City of Portland, Maine - Building or Use Permit Application

Job No: 2012-08-4806-ALTR 2012-50253-AMEND	Date Applied: 11/15/2012	CBL: 430- A-007-001	
Location of Construction: 25 LENNOX ST	Owner Name: ALLISON BROWN	Owner Address: 25 LENNOX ST PORTLAND, ME 04103	Phone: 207-650-9756
Business Name:	Contractor Name: Rush Brown	Contractor Address: 125 Newbury St., Portland, ME 04101	Phone: 207-650-6204
Lessee/Buyer's Name:	Phone:	Permit Type: Building	Zone: R-3
Past Use: Single family	Proposed Use: Same - single family amend permits #2012-07-4408, 2012-08-4665 & #2012-08-4806 - changing staircase to attic to spiral staircase	Cost of Work: \$2,000.00	CEO District:
		Fire Dept: <input type="checkbox"/> Approved <input checked="" type="checkbox"/> Denied <input type="checkbox"/> N/A	Inspection: Use Group: R3 Type: SB IRC 2009 Signature: <i>[Signature]</i>
Proposed Project Description: change attic staircase to spiral staircase		Pedestrian Activities District (P.A.D.)

Jonathan Rioux - RE: Fwd: Lennox 25 House - Spiral Stair Floor Framing Details

CSK-5

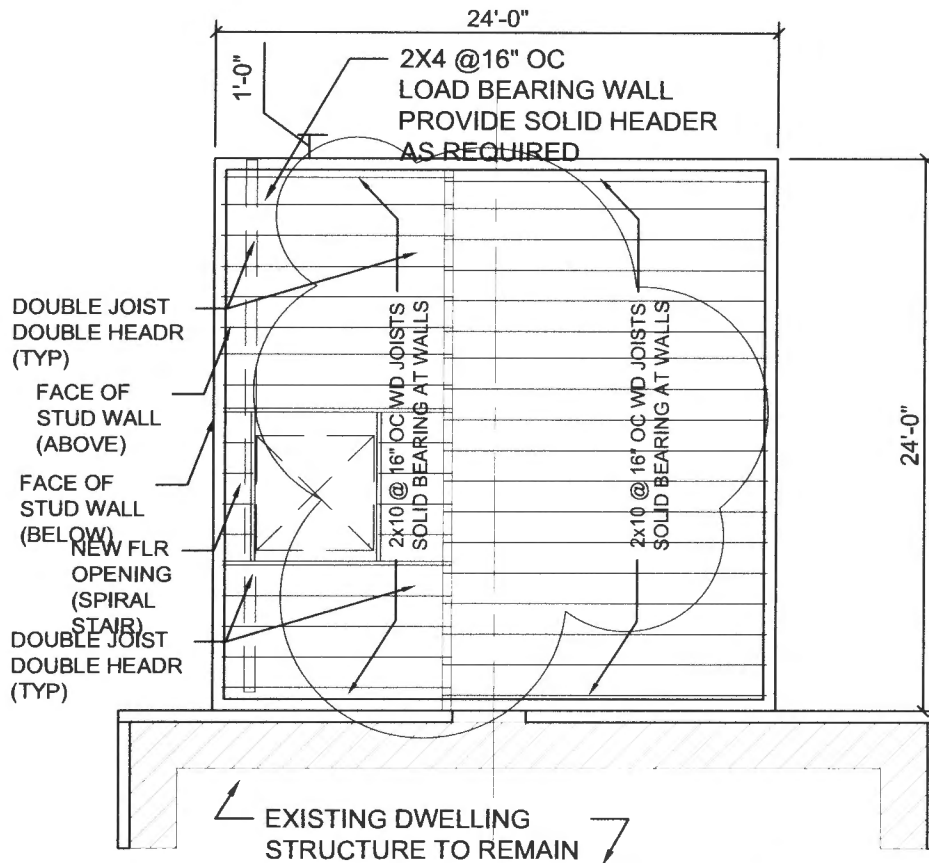
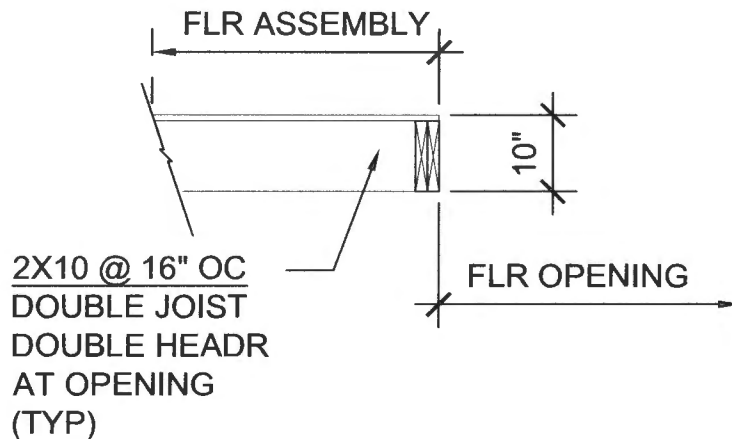
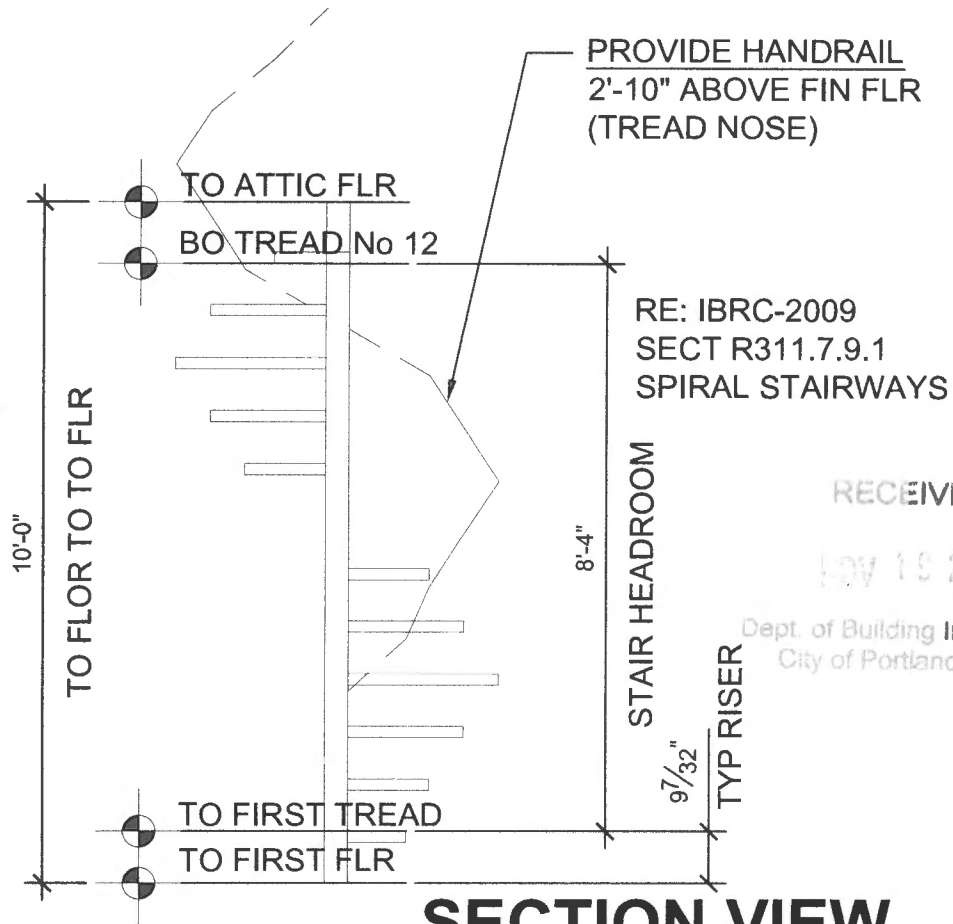
Couple quick questions for the Lennox Street Project.

- What did you design the live load for the "attic storage" area?
- Is there an emergency escape for the habitable attic area?

R502.3.1 Sleeping areas and attic joists. Table R502.3.1(1) shall be used to determine the maximum allowable span of floor joists that support sleeping areas and attics that are accessed by means of a fixed stairway in accordance with Section R311.7 provided that the design live load does not exceed 30 pounds per square foot (1.44 kPa) and the design dead load does not exceed 20 pounds per square foot (0.96 kPa). The allowable span of ceiling joists that support attics used for limited storage or no storage shall be determined in accordance with Section R802.4.

- LL=40 psf (SPF #2 or better) (2x10 @16 OC w/ DL = 10psf)
- Yes, emergency escape is provided (second story/glazed window). The primary occupancy use of the Attic area is storage for Mr. Brown's artwork. Furthermore, it's my understanding that the new house will be fully sprinklered in accordance with NFPA-13R as required by the City's FP rules. Note: By building code ruling, Emergency escape is except for habitable spaces when the building is sprinklered, nevertheless windows are being provided at two sides: a)one unit at end gable wall (approx. 3x5 ft RO size window) and a triple dormer wall (approx. 9x3 ft RO size window)
